CLEAR VIEW INDUSTRIAL PARK, FILING 2A

GRADING, STORM AND EROSION CONTROL PLANS

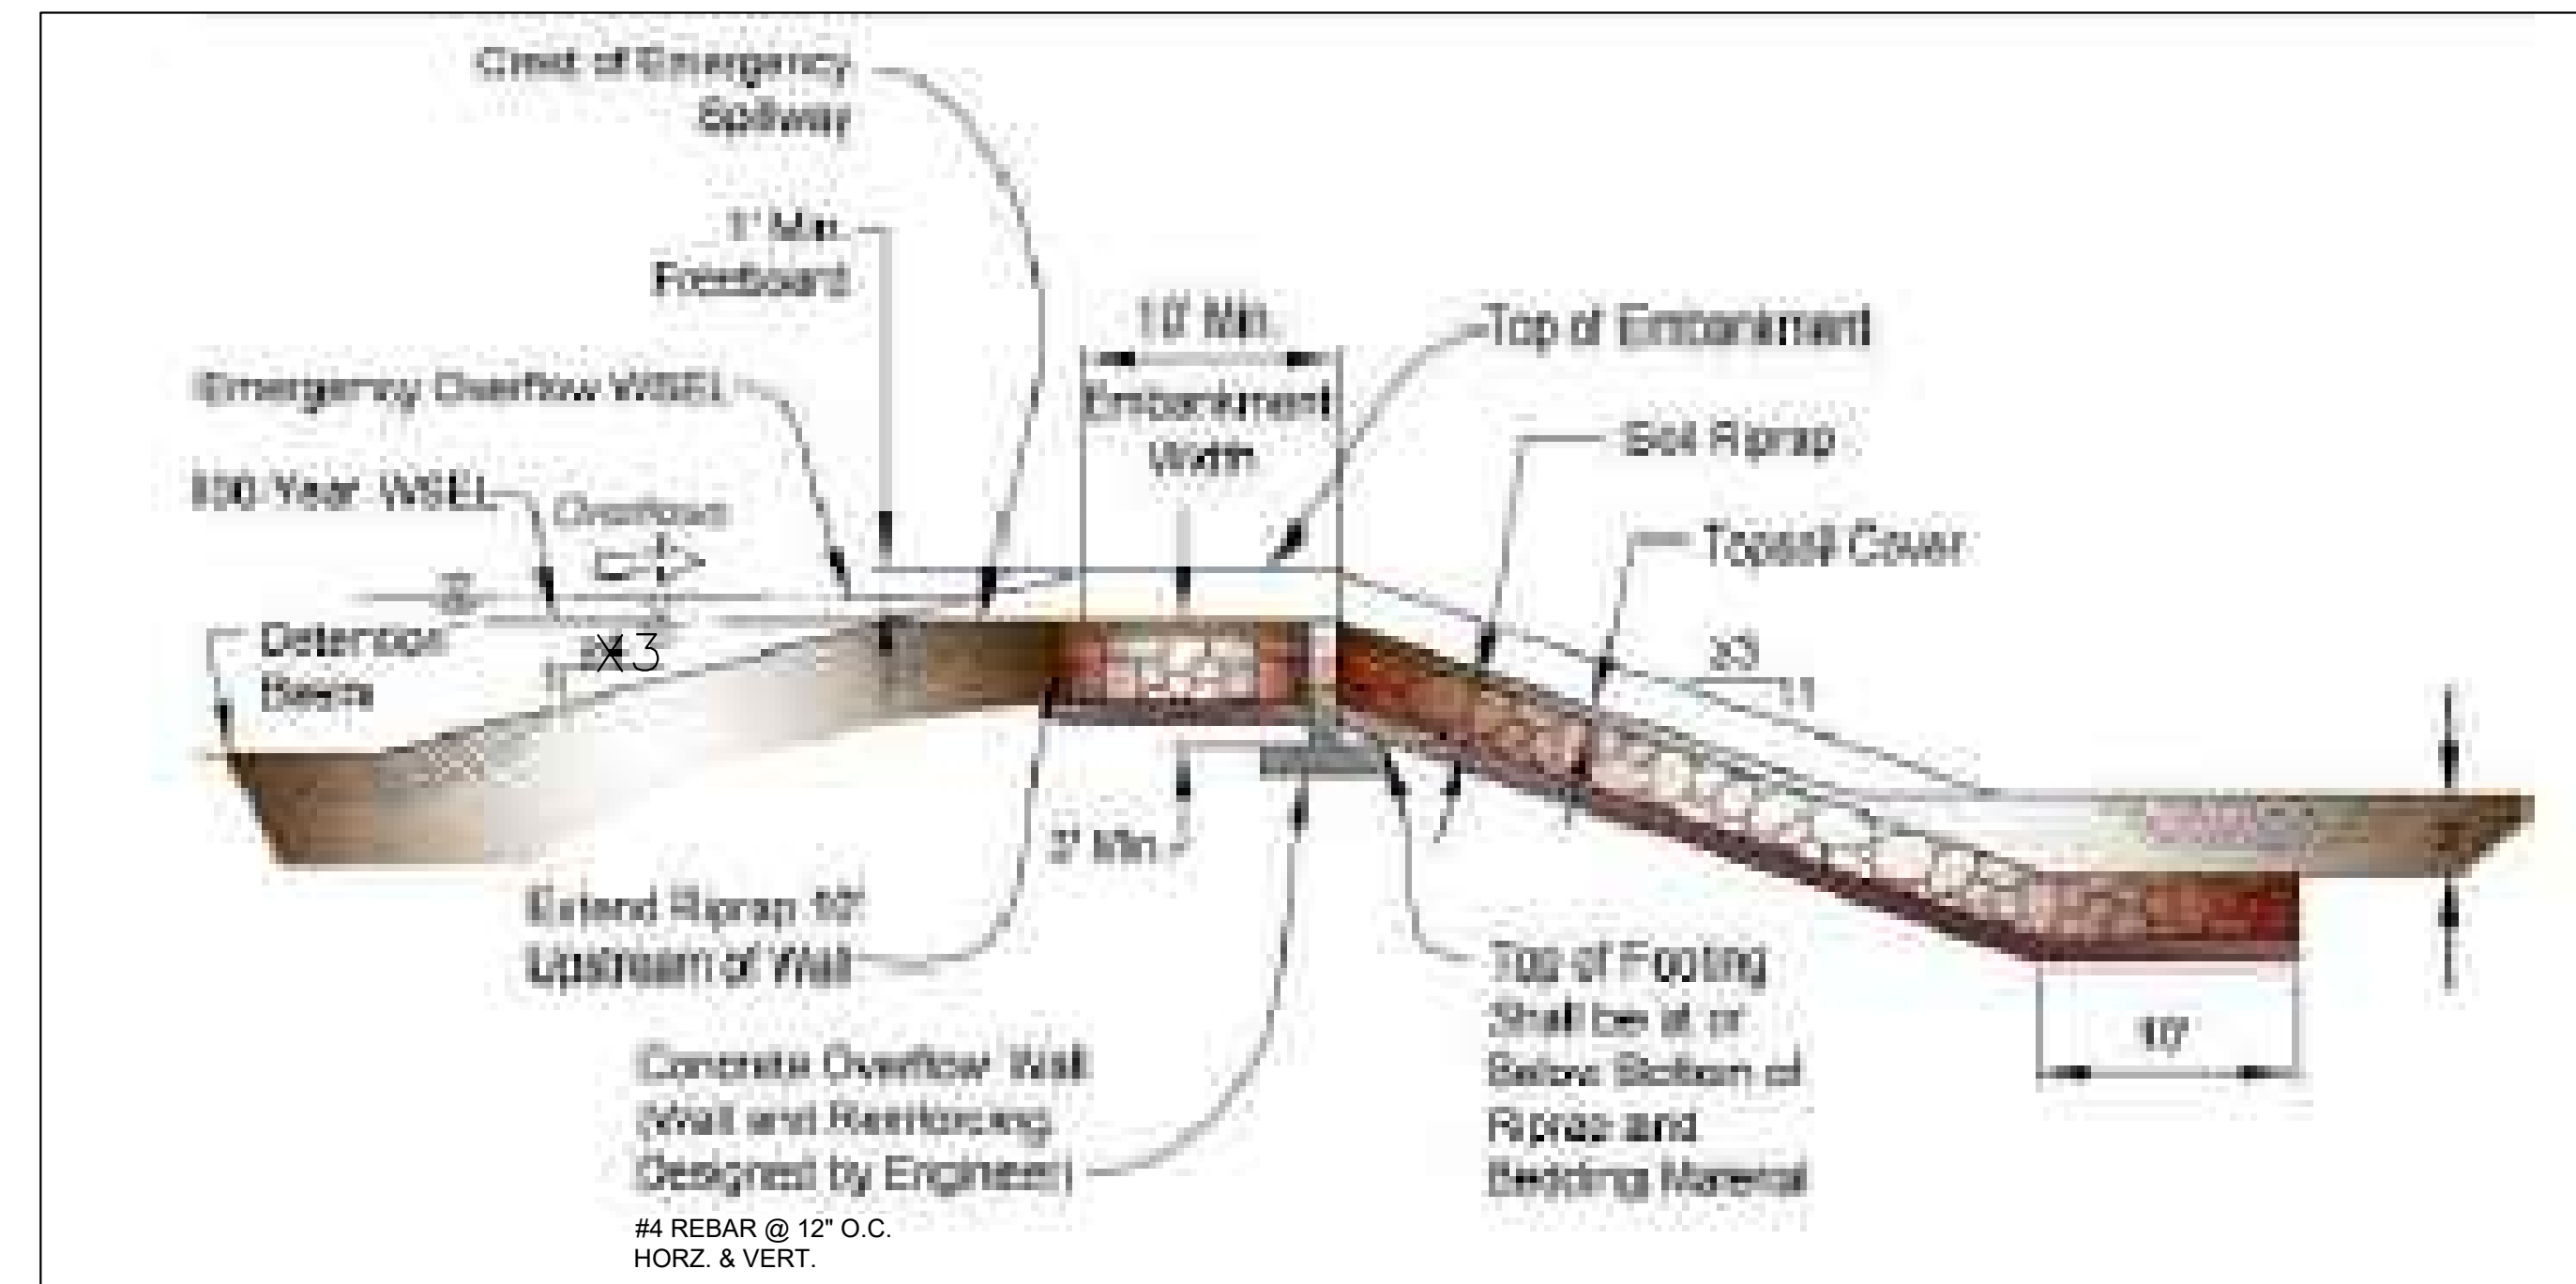
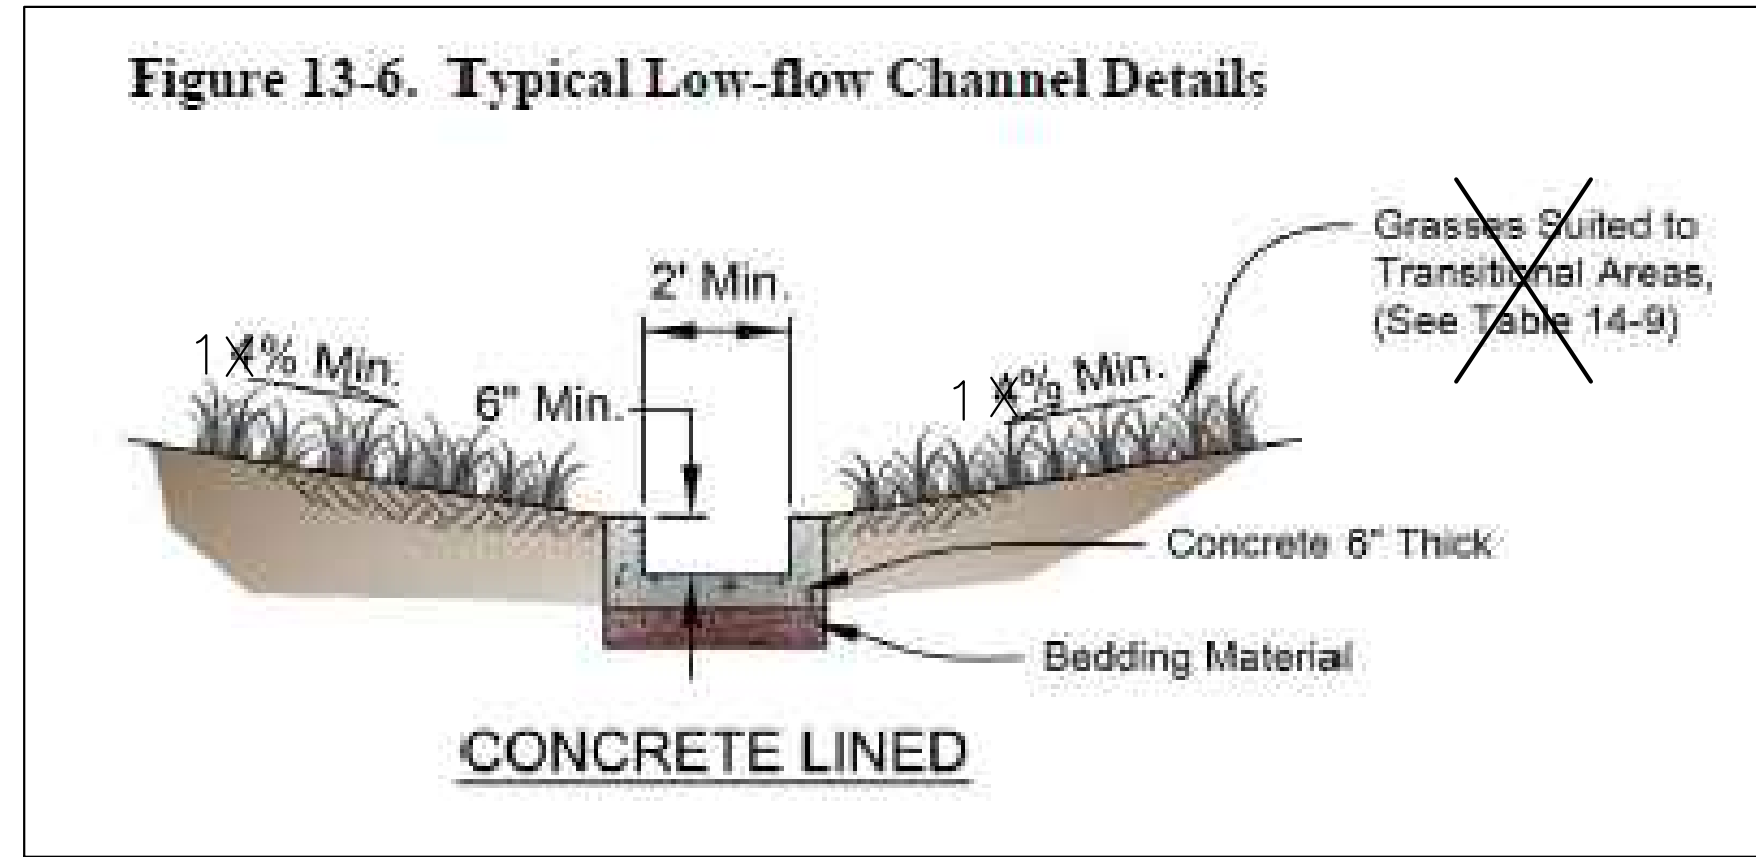
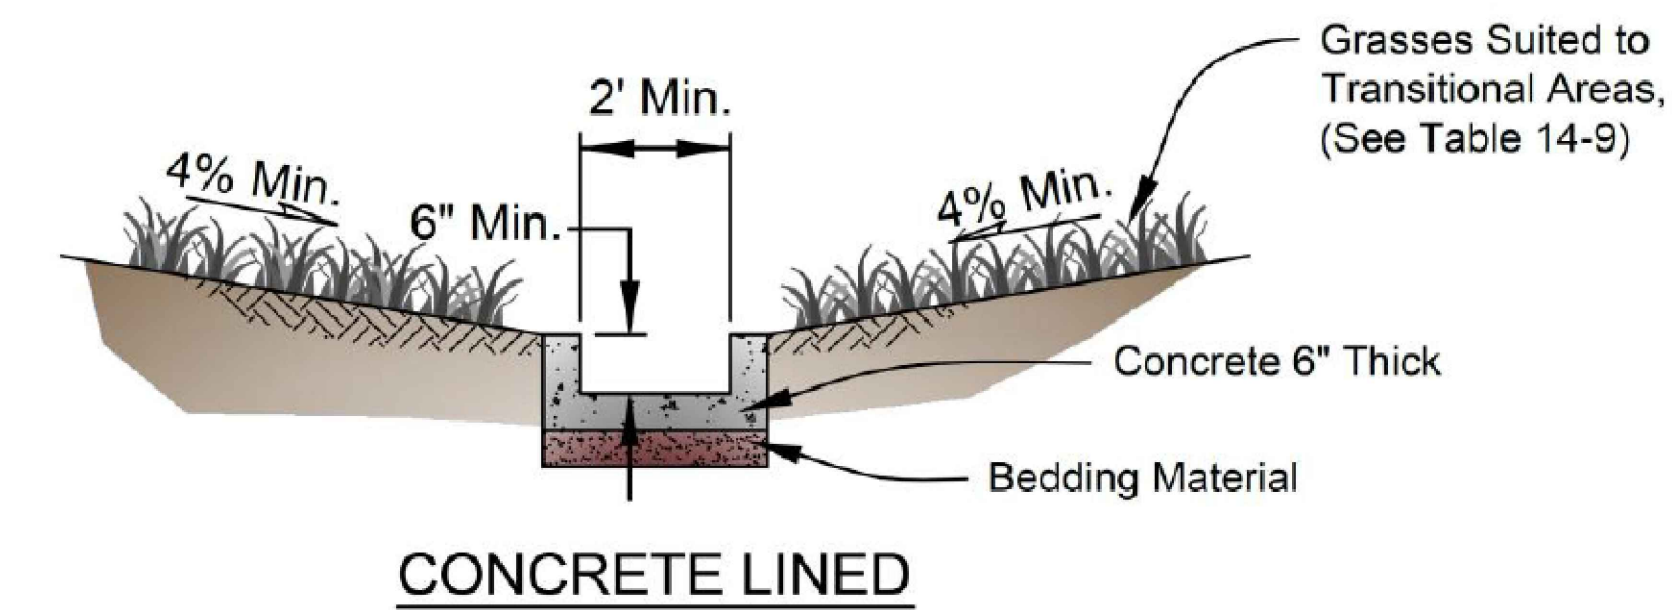
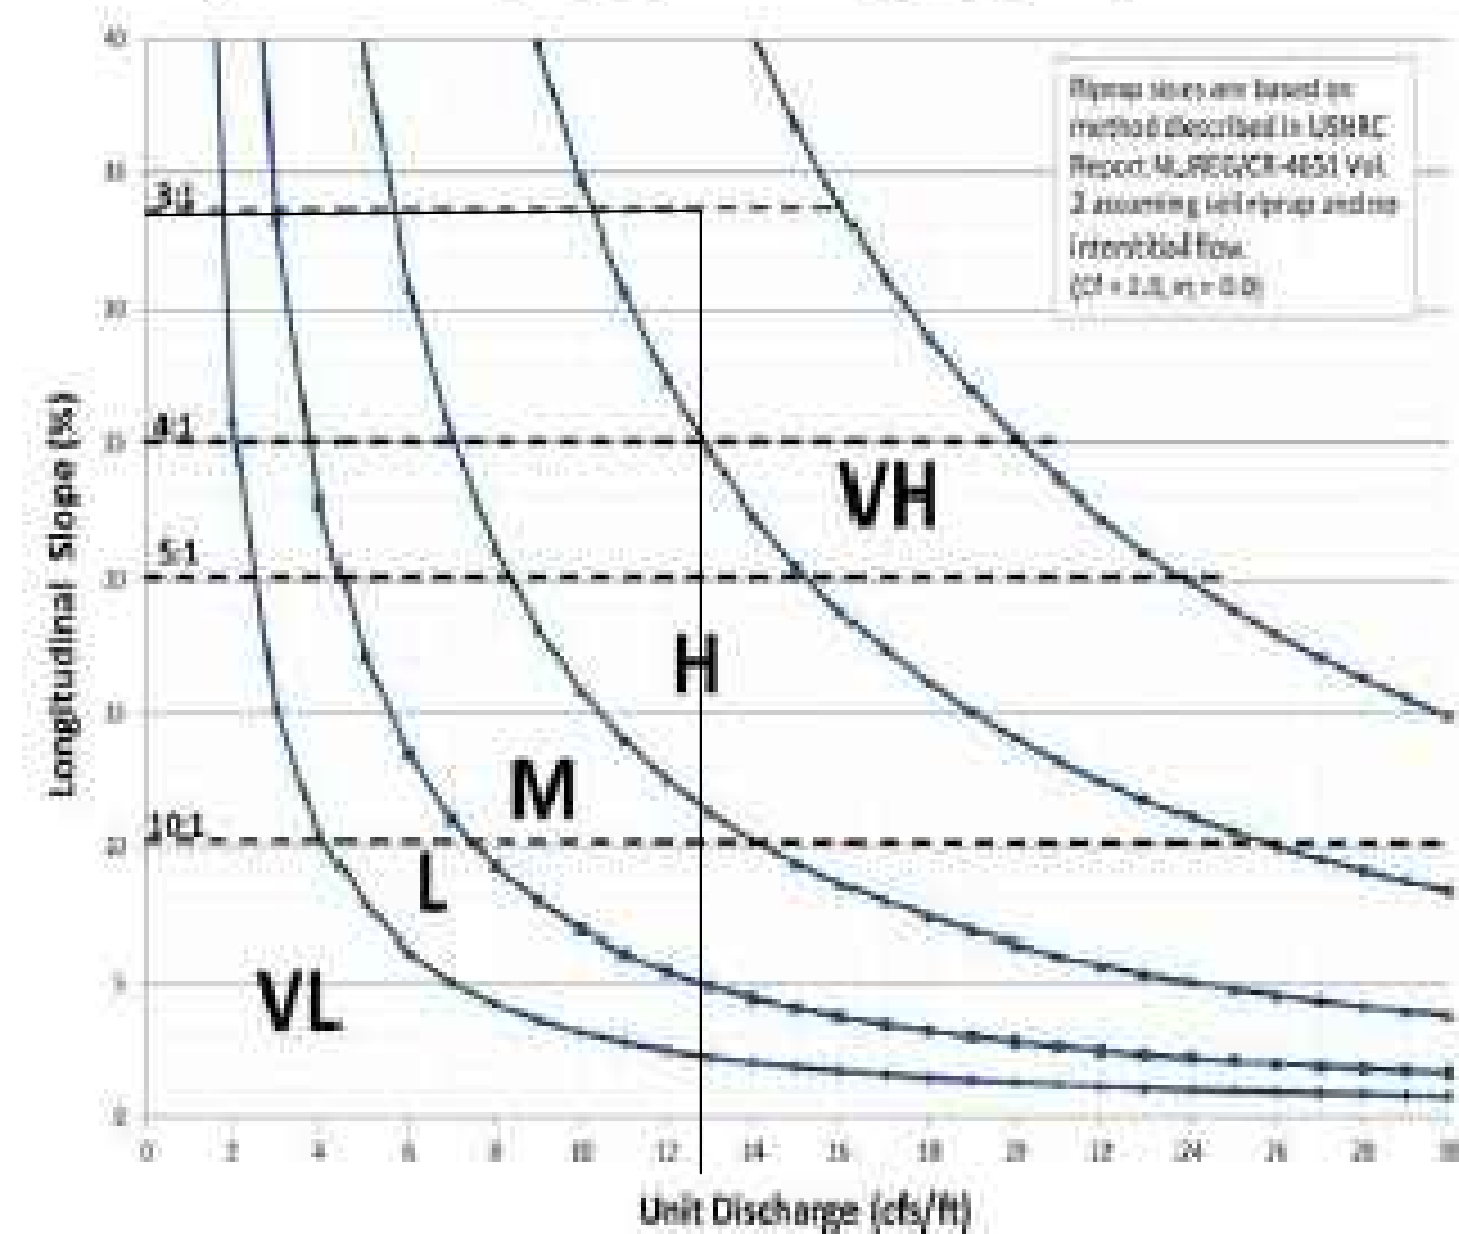
Remove. This appears to be a duplicate
